Comments on responses by the Applicant to the Examining Authority's First Written Questions

Part B Specific Comments relating to REP2-025

Project				Status		
Botley West Solar Farm				Illustrative		
Id.	Changes	Date	Name	Date	Name	
				Edit	01.11.2024 V. Guskova	
				Check	01.11.2024 T. Hichem	
				Drawing No	EN010147/APP/6.4	
A	Created	01.11.2024	VG

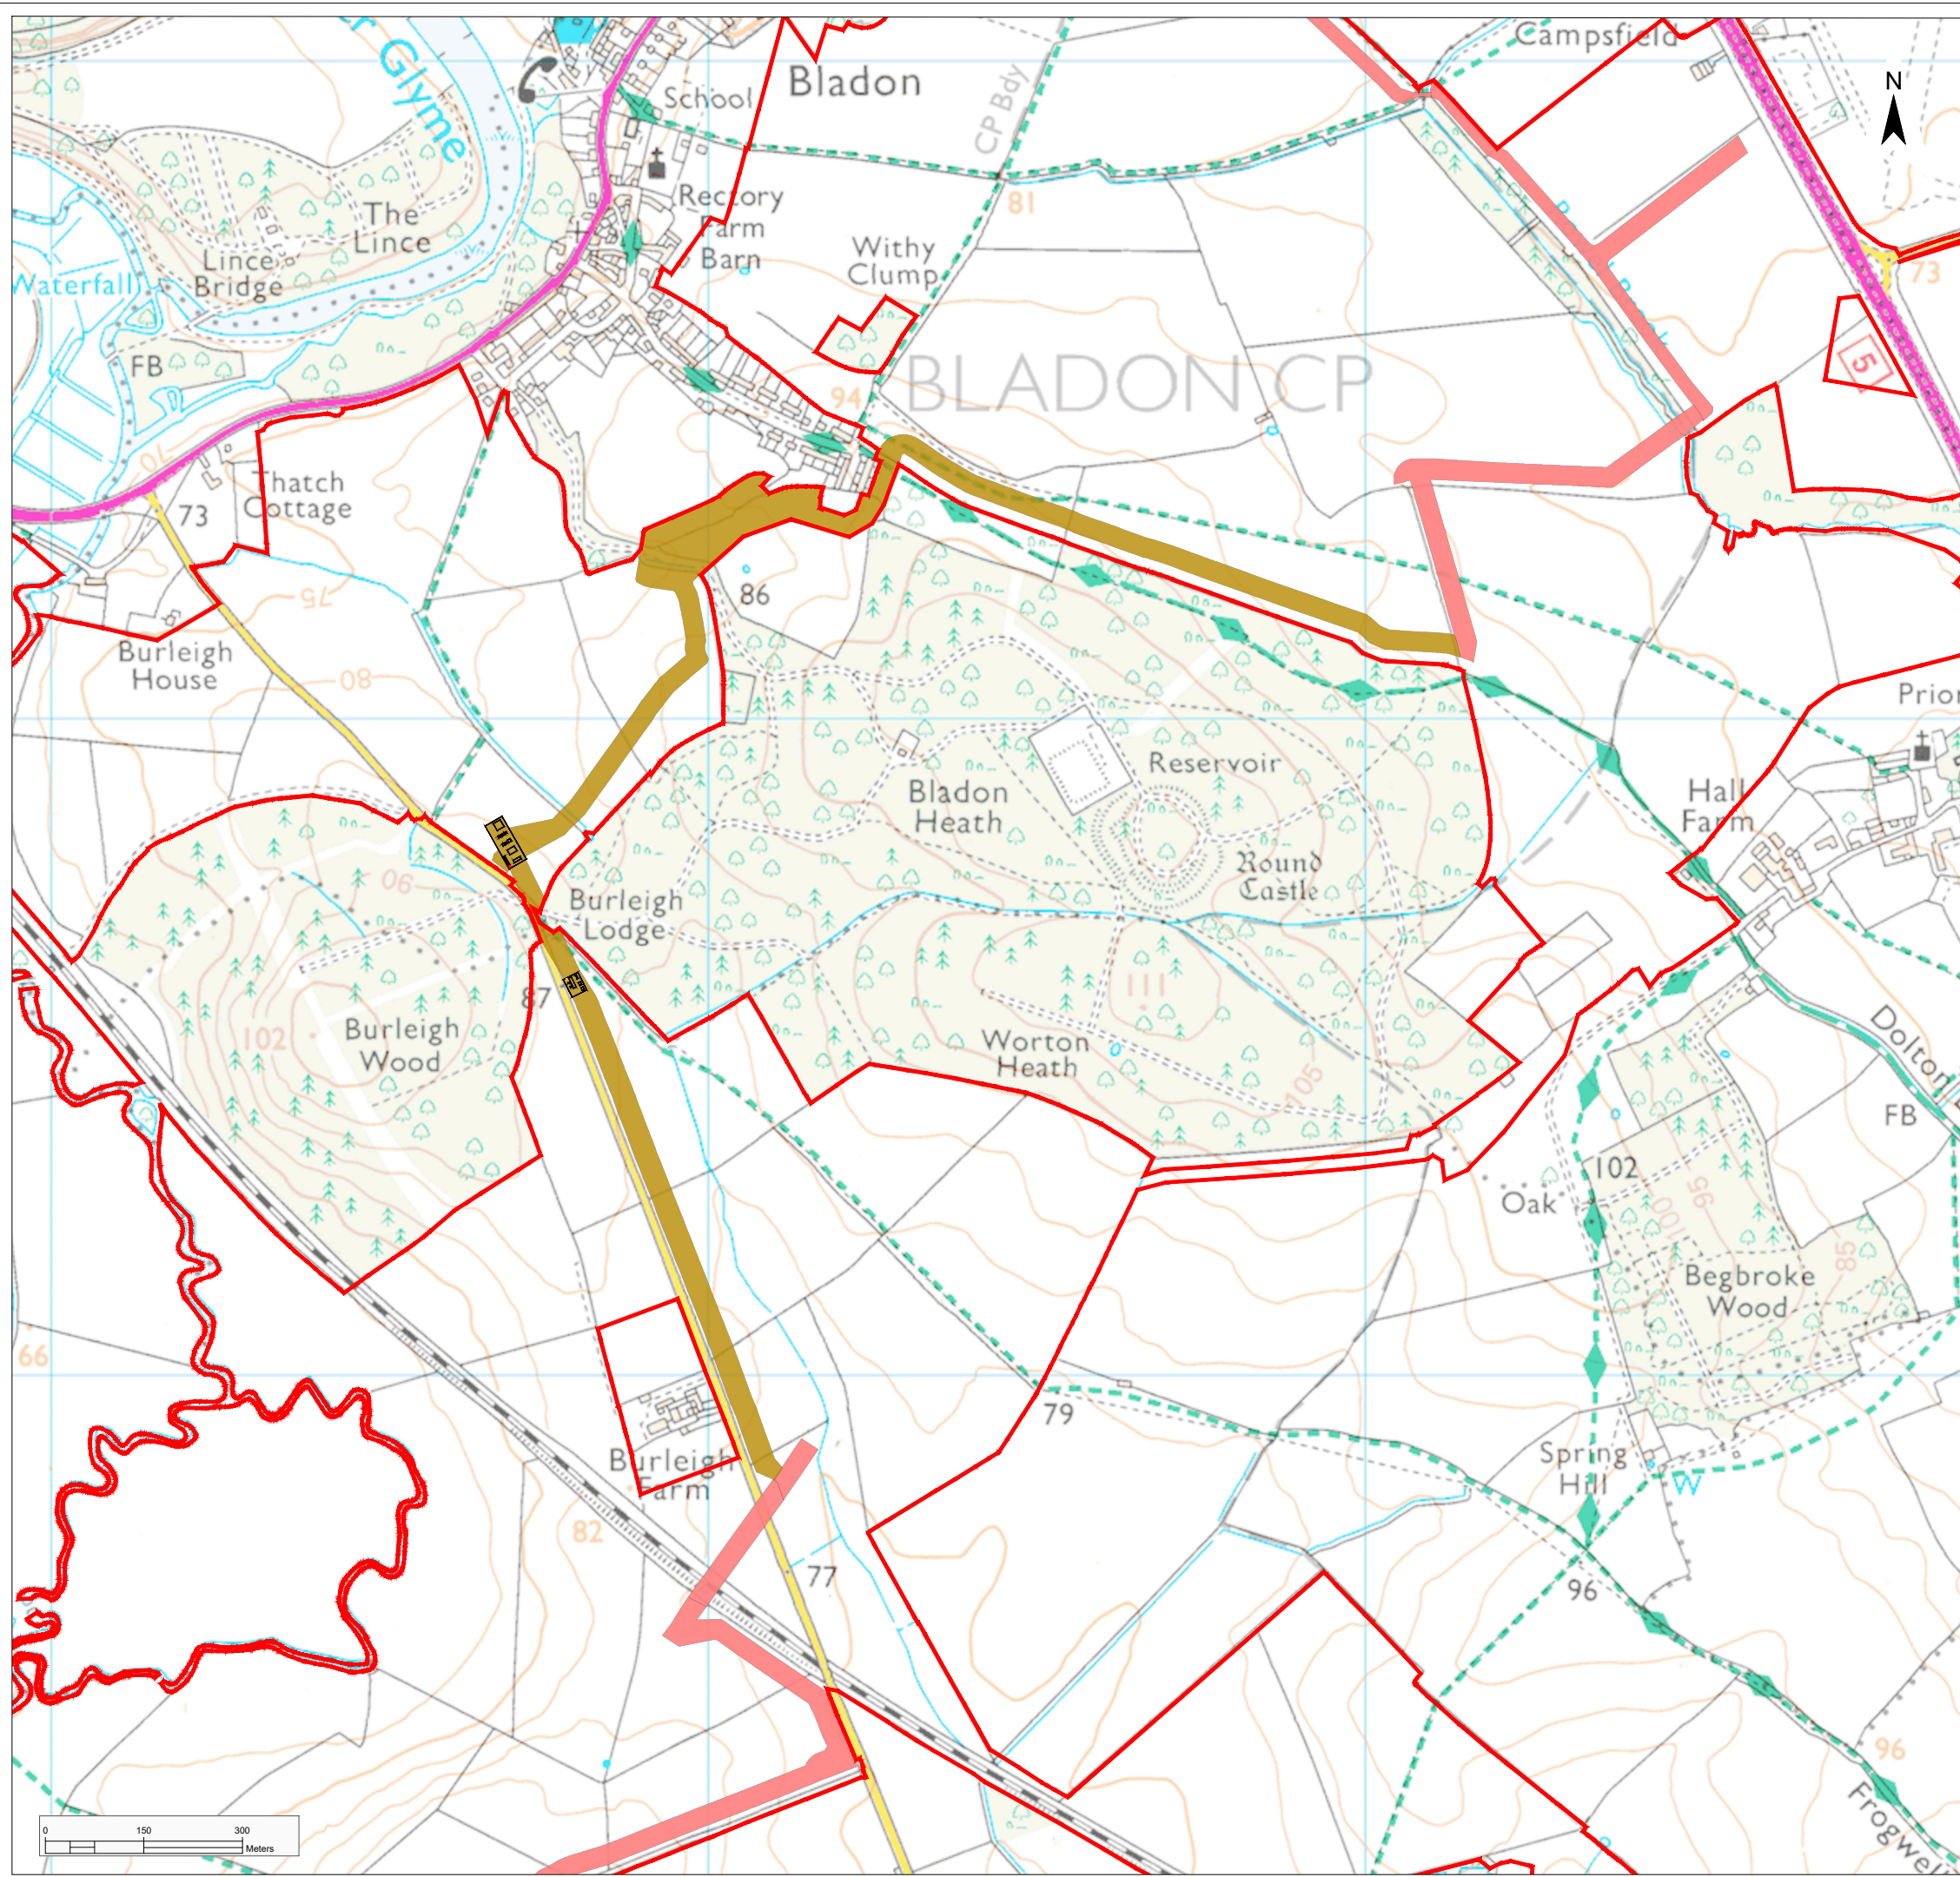
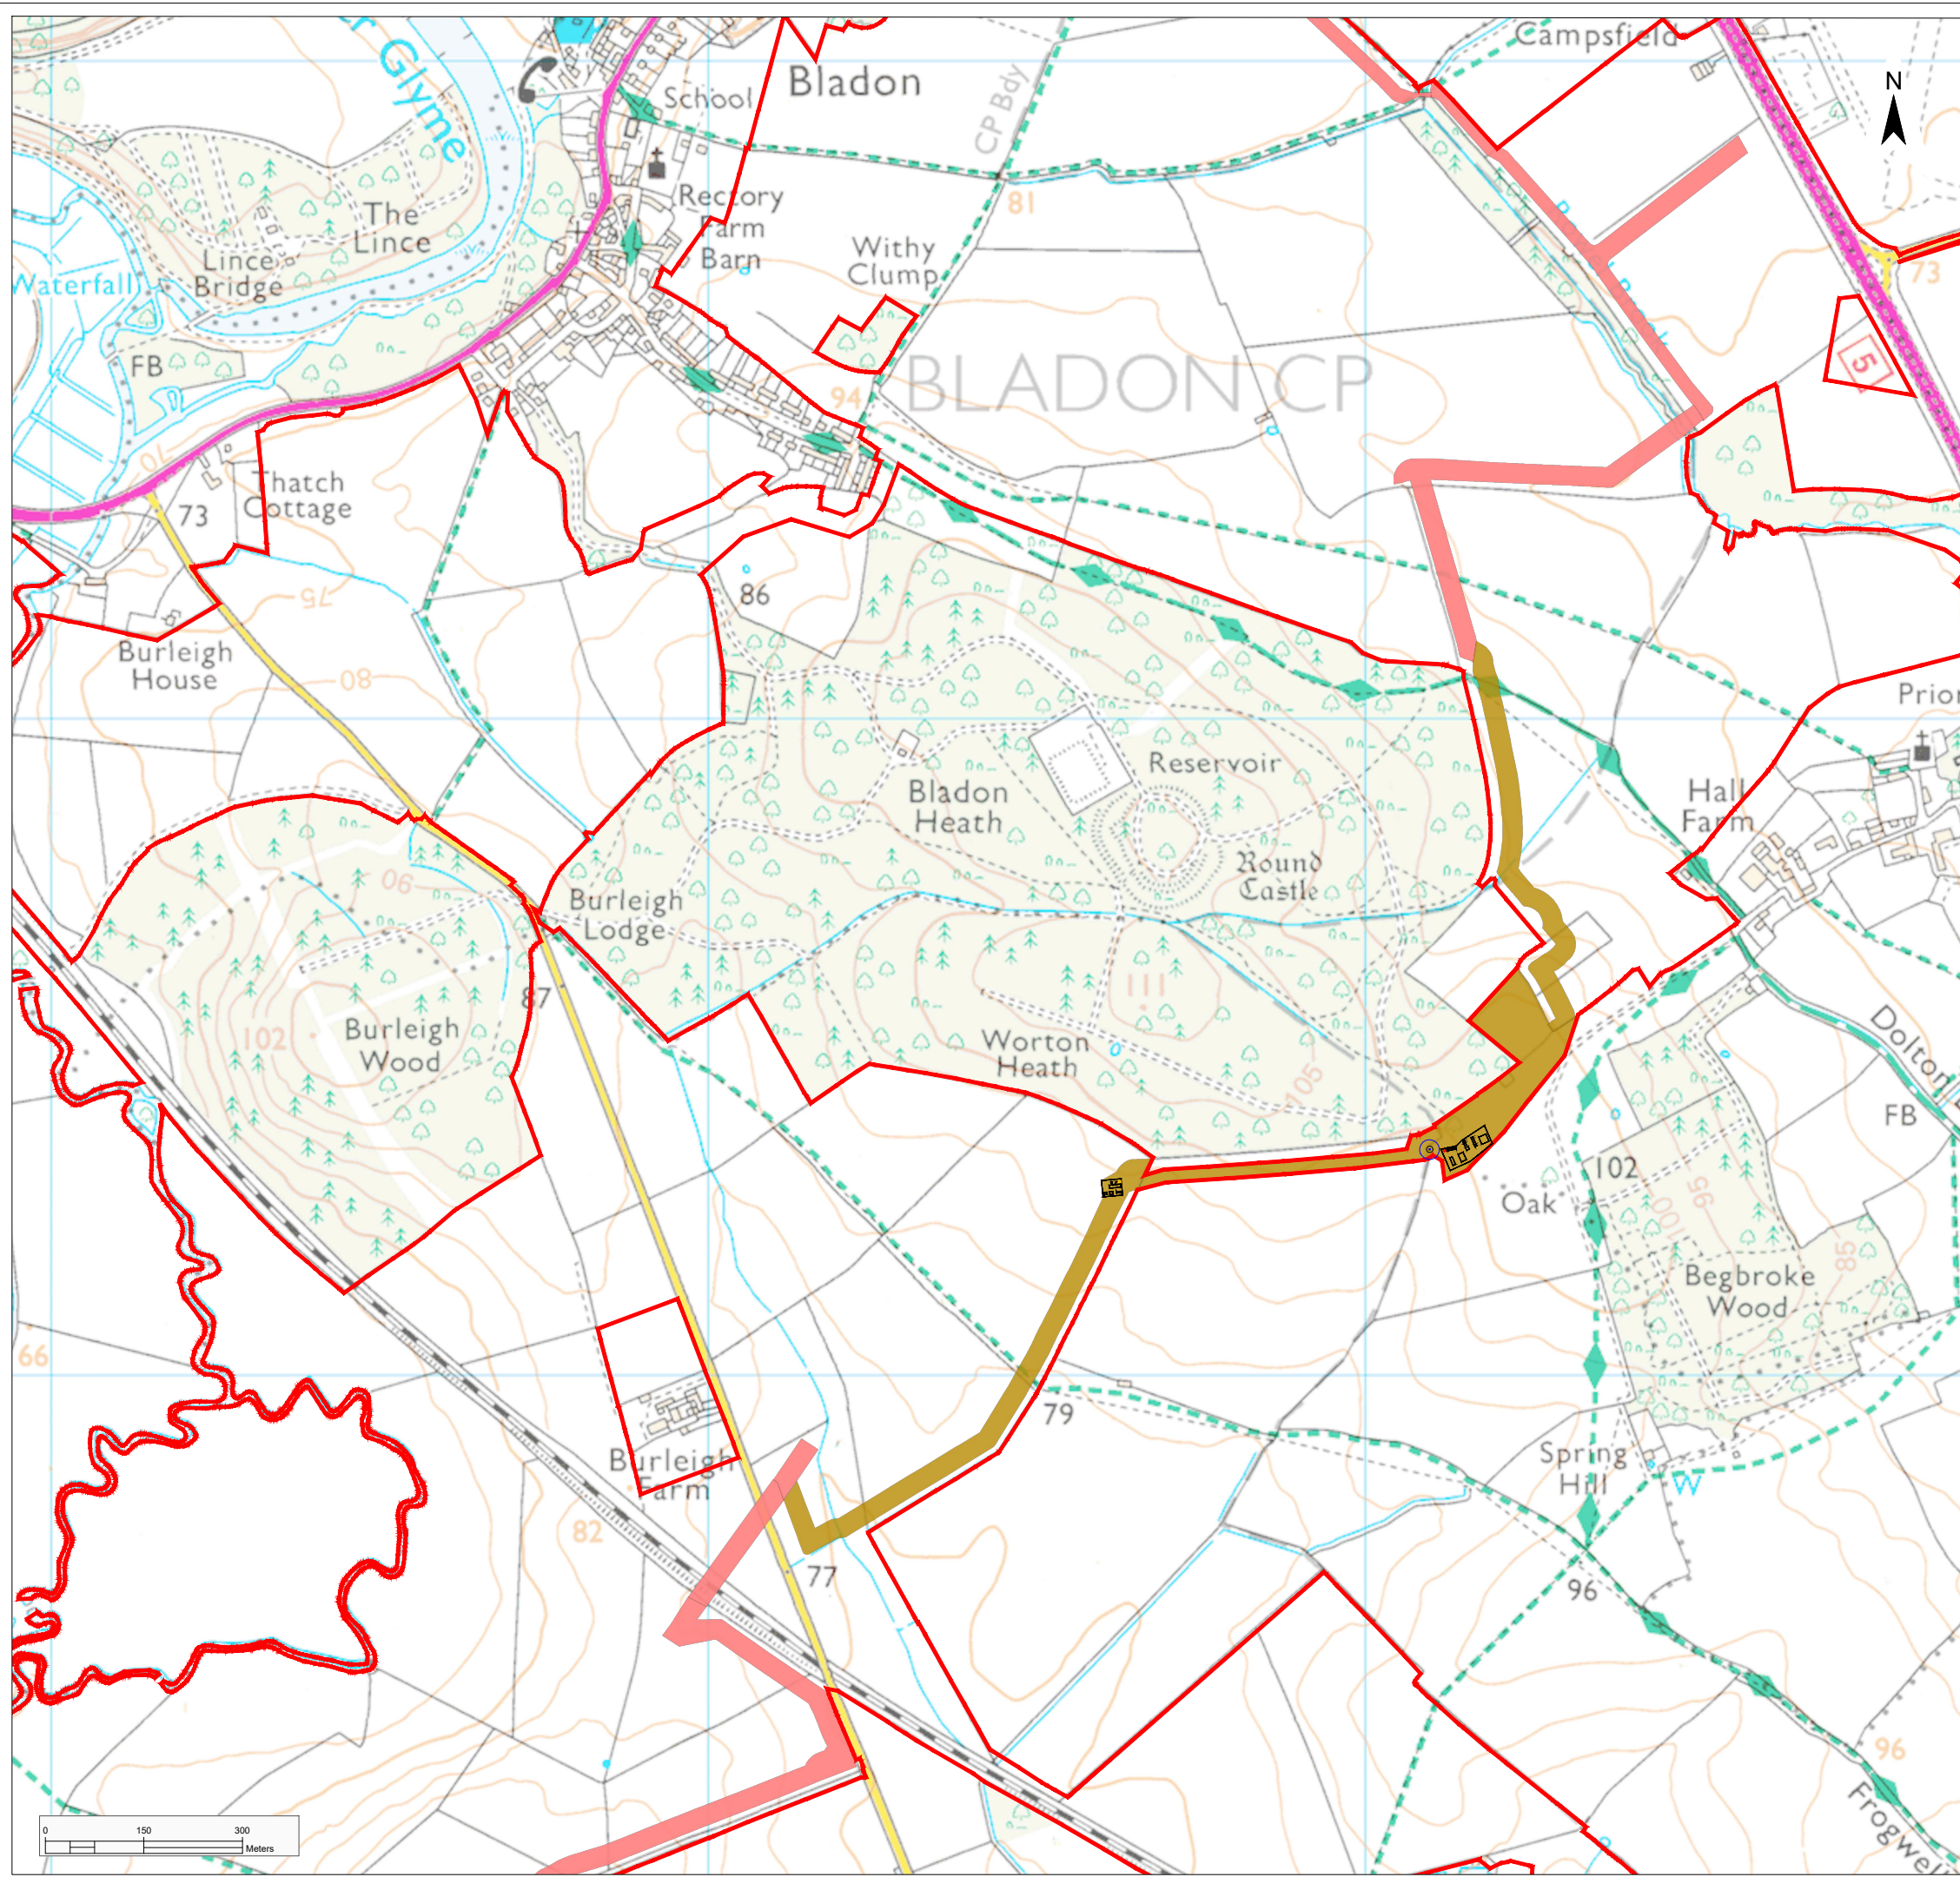
10.2 As for the 'skyline', I referred in paragraph 6 of my Written Representation (REP1-155) to the Applicant's misleading statement about 'keeping off high ground' (APP-034 at page 79). For example, the Illustrative Masterplans clearly show panels along the Purwell Farm ridge. Parts of this ridge are shown on the 3rd and 4th photographs in my 'Nomination for location for an ASI' (REP2-121)
